RESPONSE TO PLANNER

33A Marketgate, Arbroath **24/00055/FULL Proposed Conversion to 2 Flats**

We refer to the email of 8 February 2024 and attach a copy of Drawing Nos. 23126 LP.A, 01A and 03A with amended proposals. We will submit the Listed Building Consent application.

ref **23126** **01A**

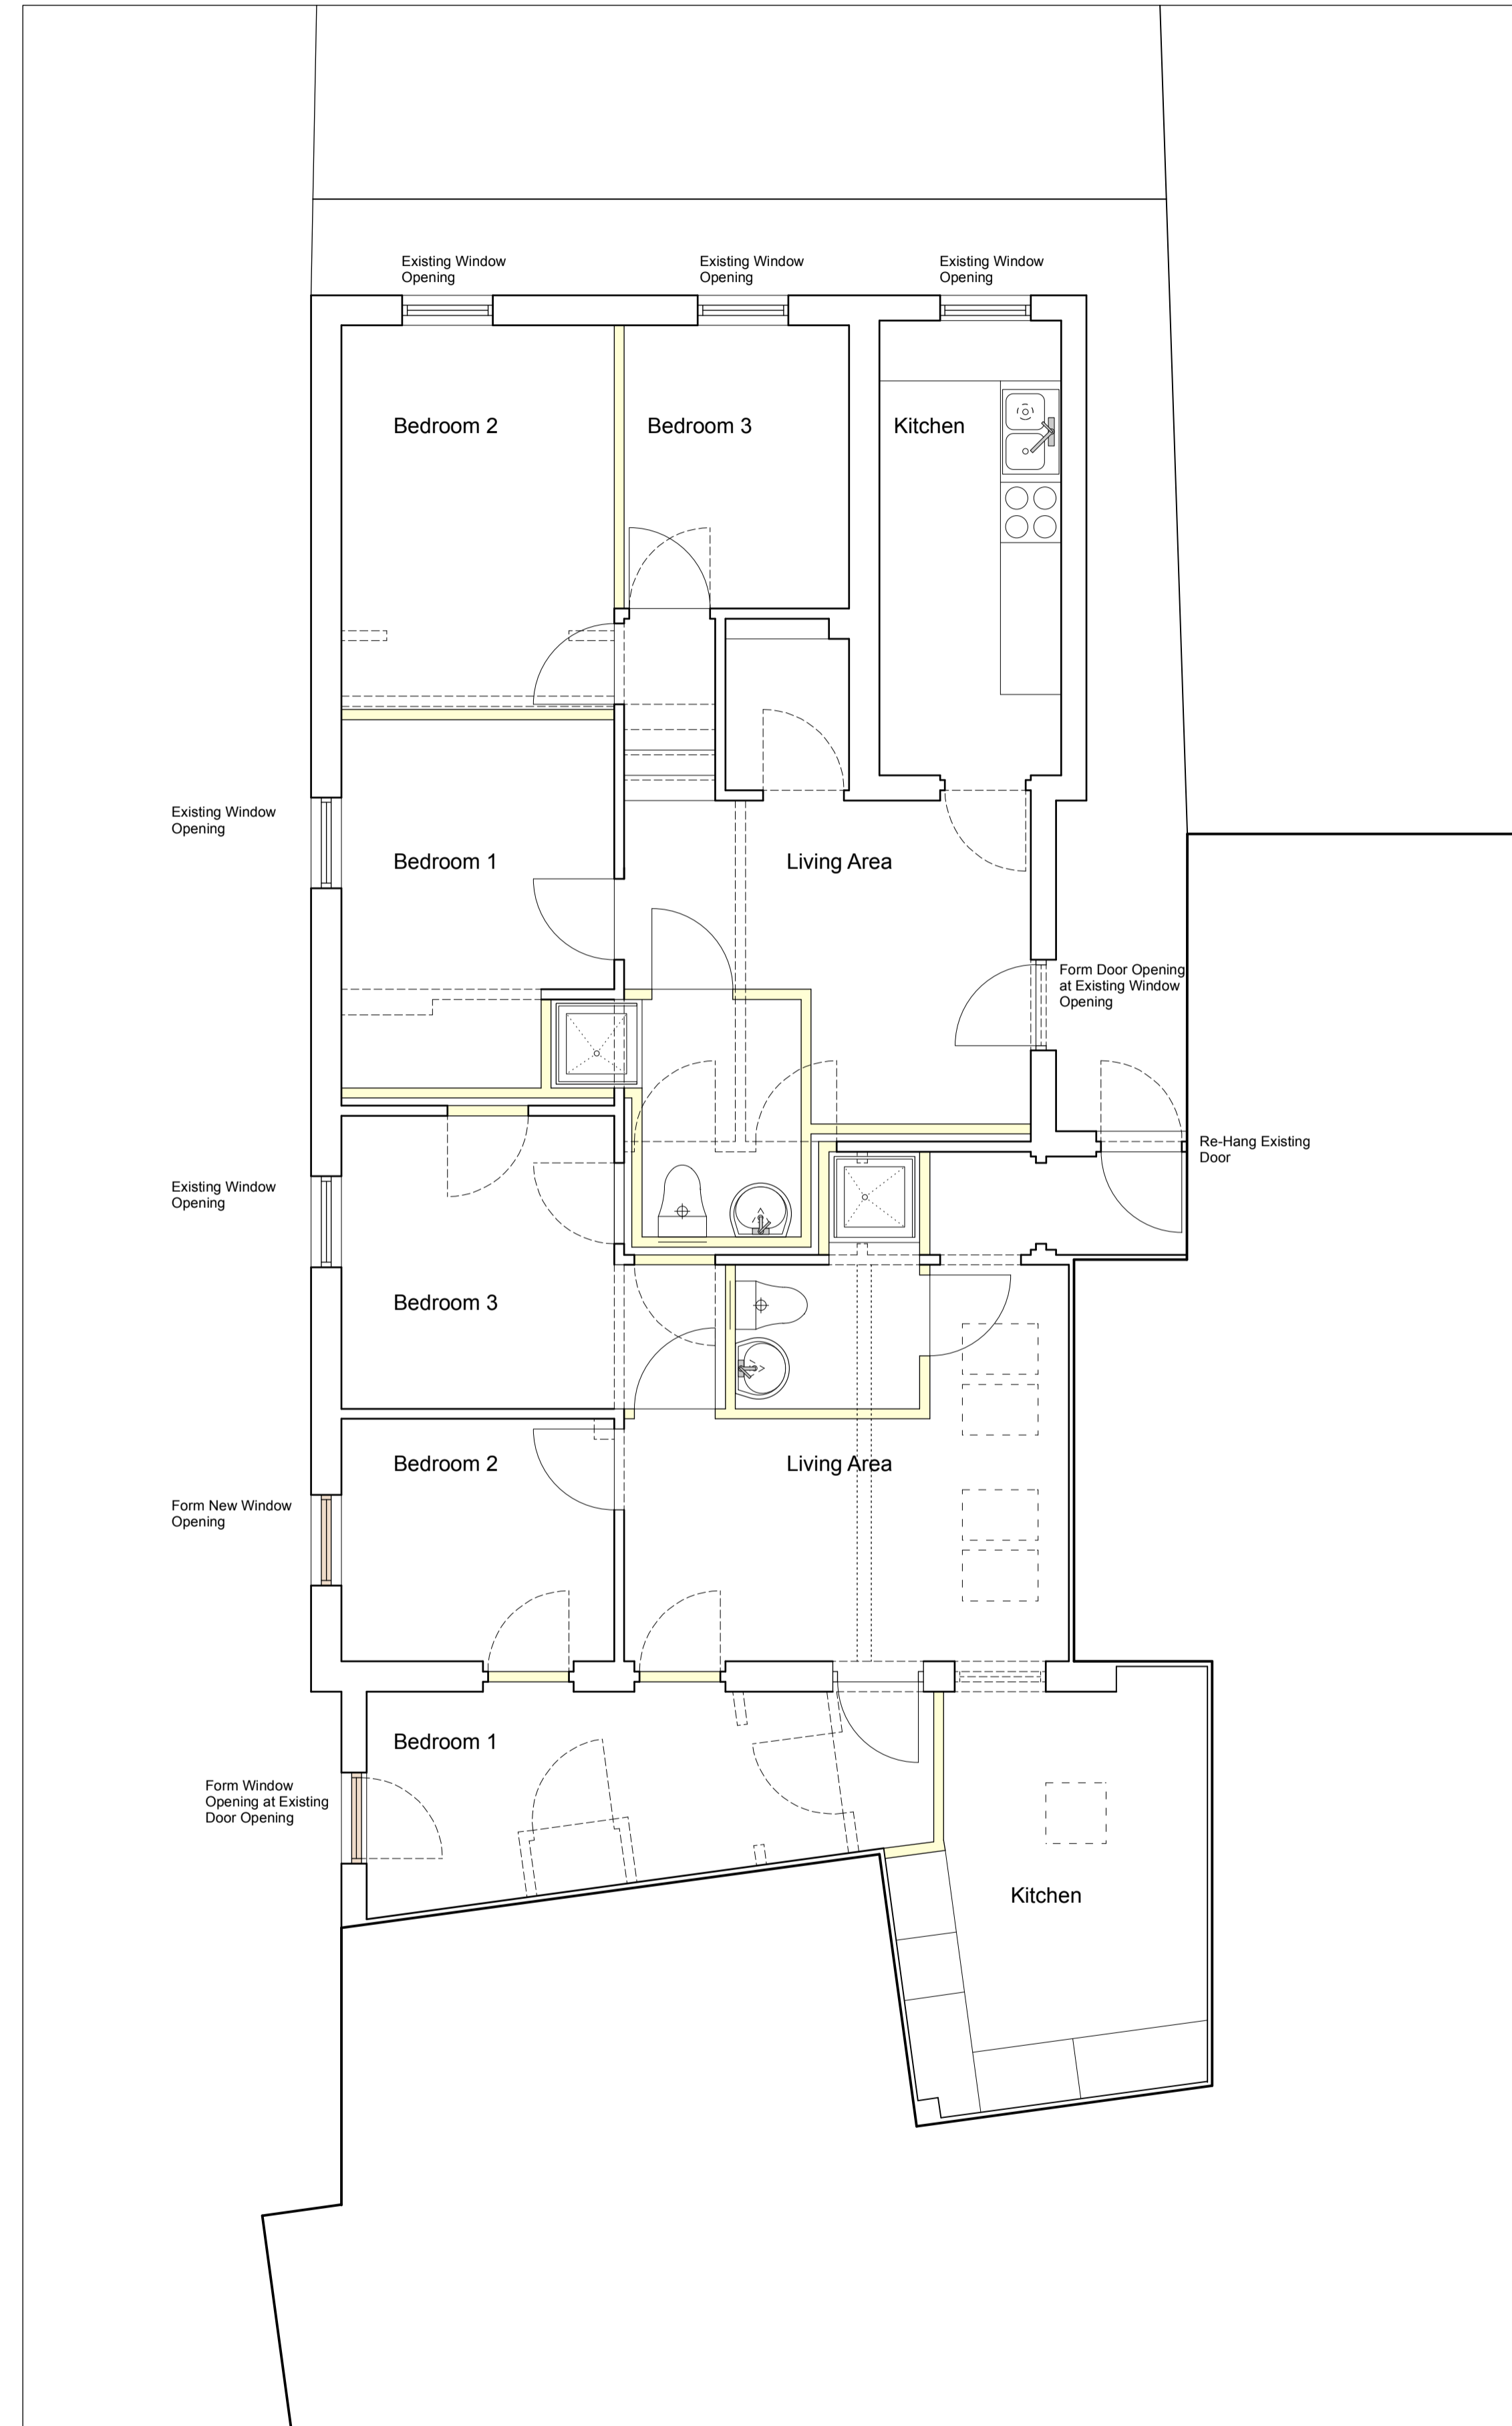
4. We have amended the floor plan noting the alterations to the building.
